WEST SUSSEX COUNTY COUNCIL CONSULTATION

TO:	Arun District Council FAO: Zac Denton
FROM:	WSCC - Highways Authority
DATE:	23 July 2019
LOCATION:	Seahaven (Land East of Ash Hollow), Seafield Road, East Preston, BN16 1NA
SUBJECT:	EP/75/19/PL 1no. new dwelling (re-submission of approved application reference EP/105/16/PL).
DATE OF SITE VISIT:	N/A
RECOMMENDATION:	Advice
S106 CONTRIBUTION TOTAL:	N/A

1:500 Block Plan

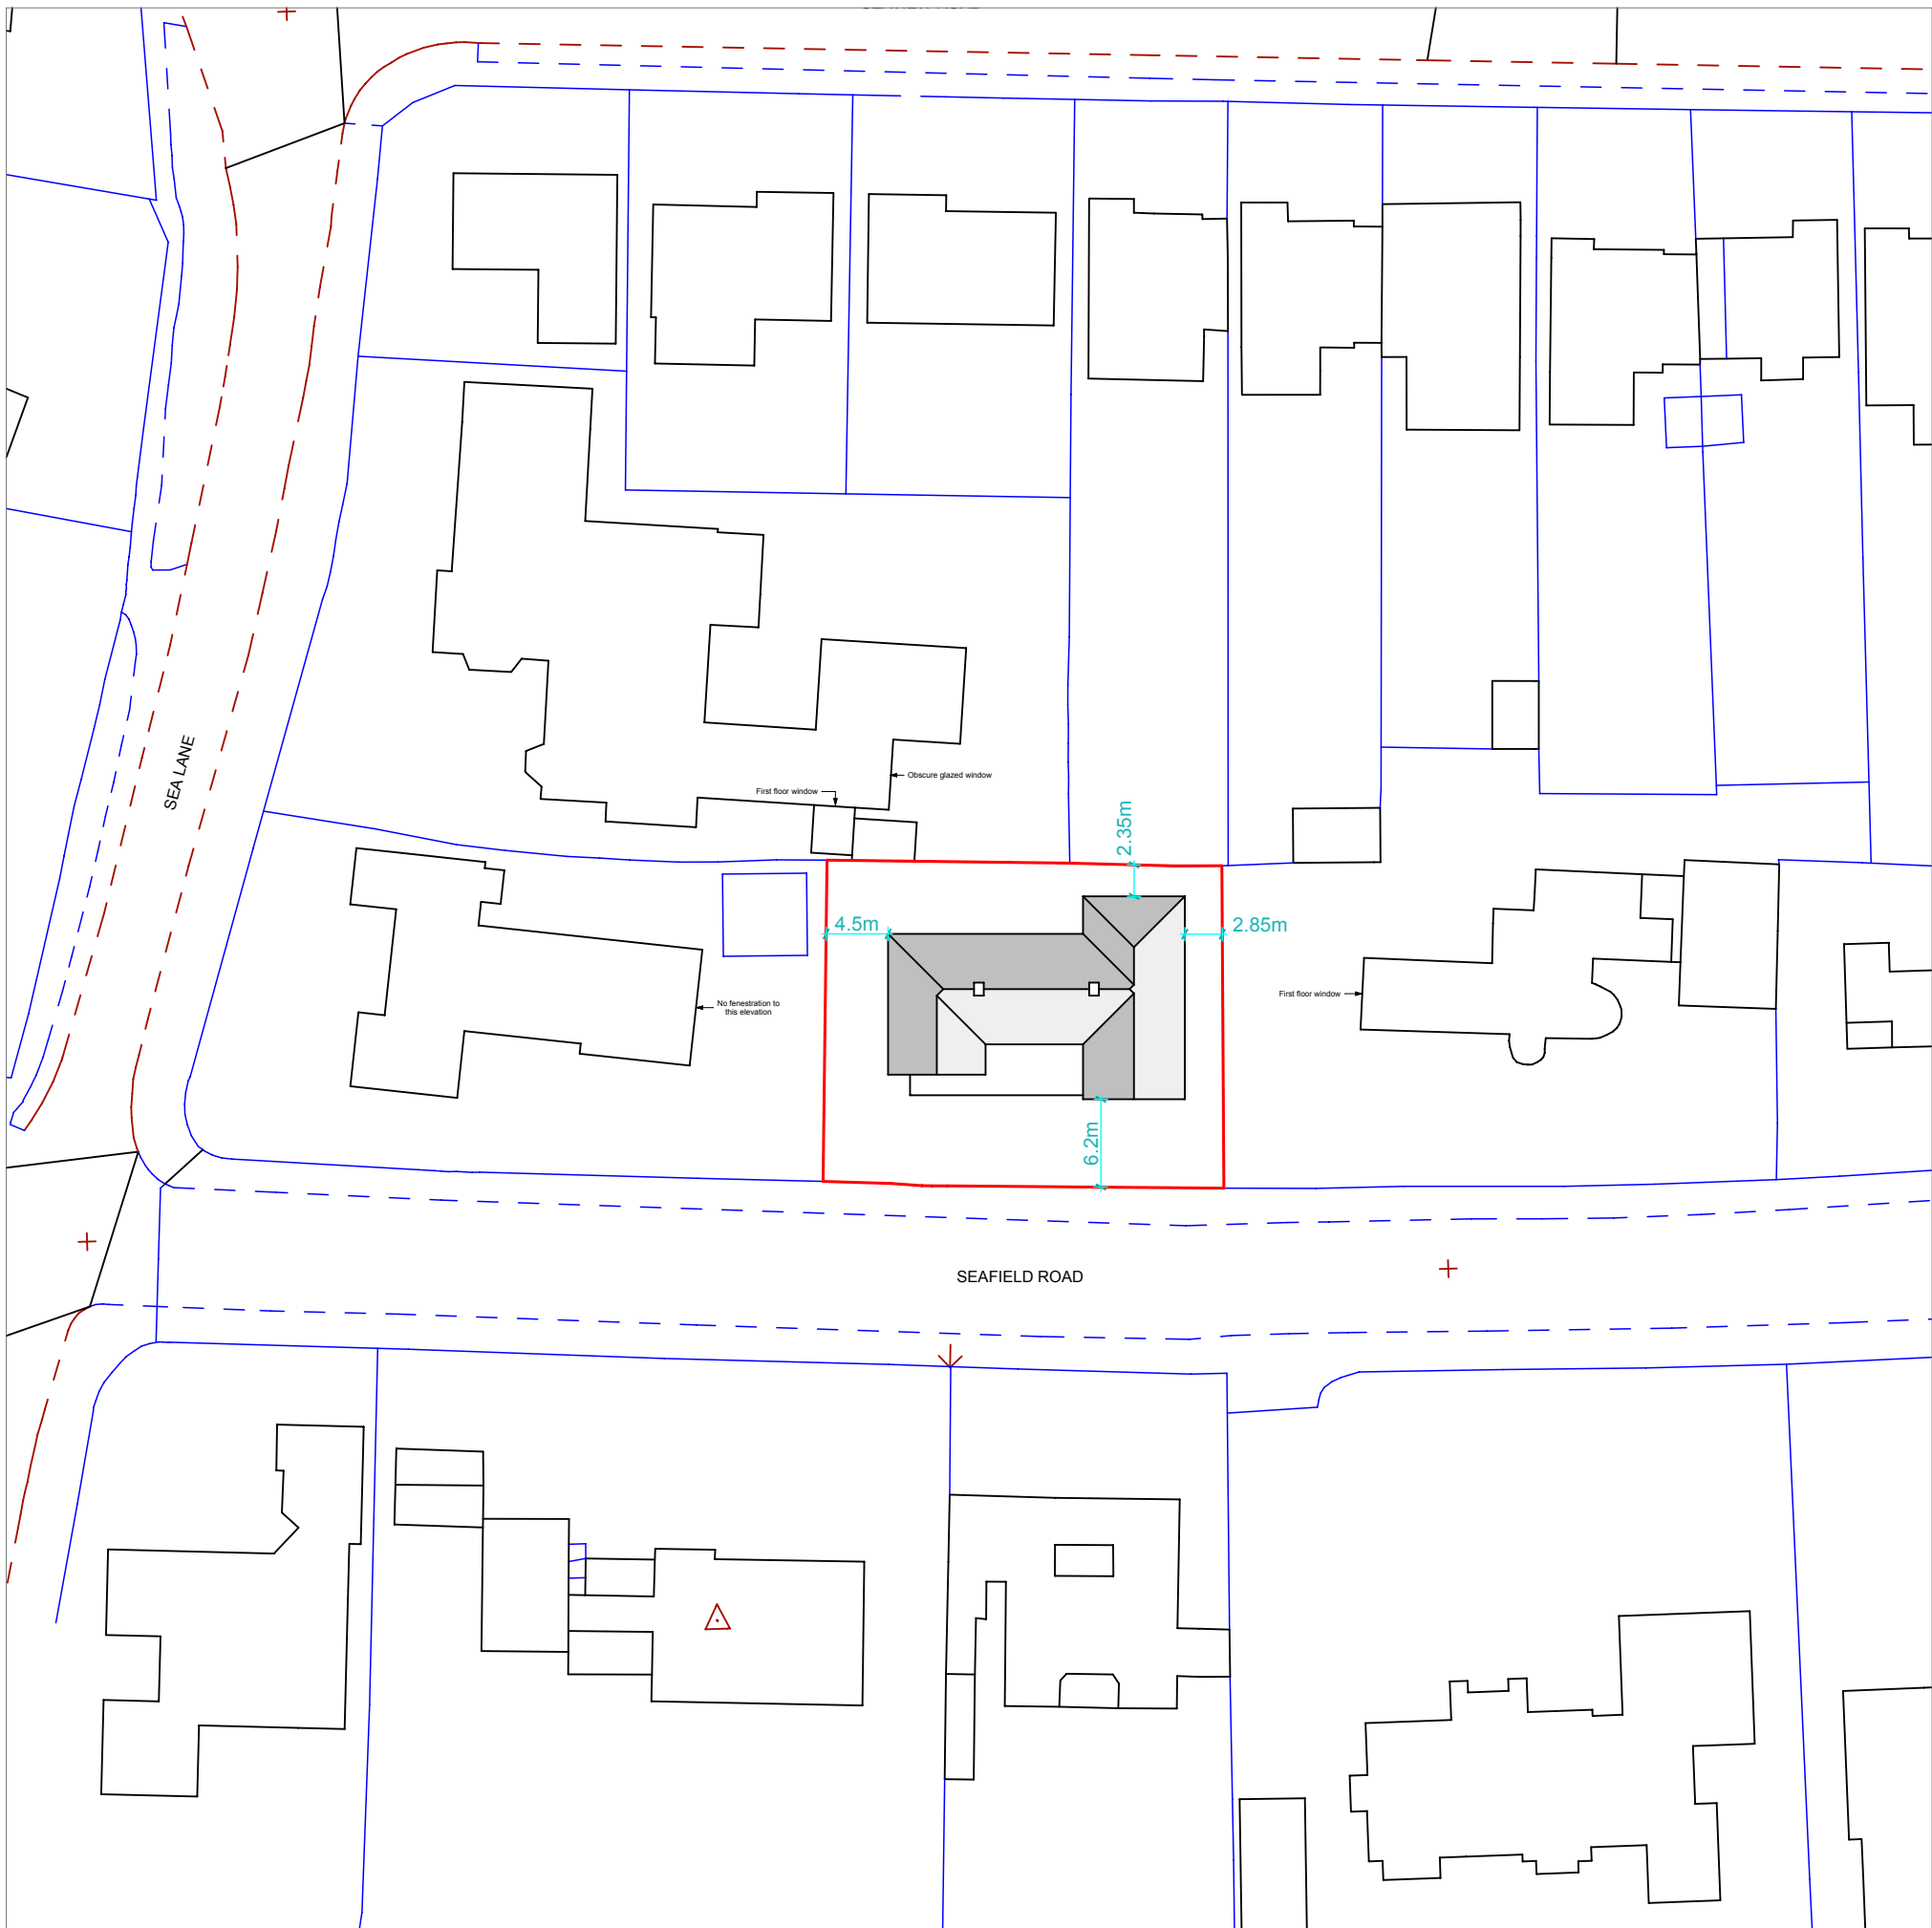
The site is located on a privately maintained road. A new access onto Seafield Road is proposed, measuring approximately 3.9m in width. The applicant is advised to contact the proprietor of Seafield Road to obtain formal approval to carry out the site access works.

3 car parking spaces are proposed for the property. This includes a parking area for 2 cars and a single car garage. The WSCC Car Parking Demand Calculator indicates that a property of this size in this location would require 3 car parking spaces, which the plans meet.

The parking area meets the minimum specifications for a double car bay of 4.8m x 4.8m as set out in Manual for Streets (MfS). The garage demonstrated in the plans has internal dimensions of approximately 3.4m x 6.3m. This meets the MfS minimum internal specifications for single car garages of 3m x 6m. A garage of this size will also allow for the secure and covered storage of cycles.

On-site turning does not appear to be achievable, so vehicles may have to exit the site onto the privately maintained road in a reverse gear.

The applicant is advised to contact the proprietor of Seafeld Road to obtain formal approval to carry out the site access works on the private lane.
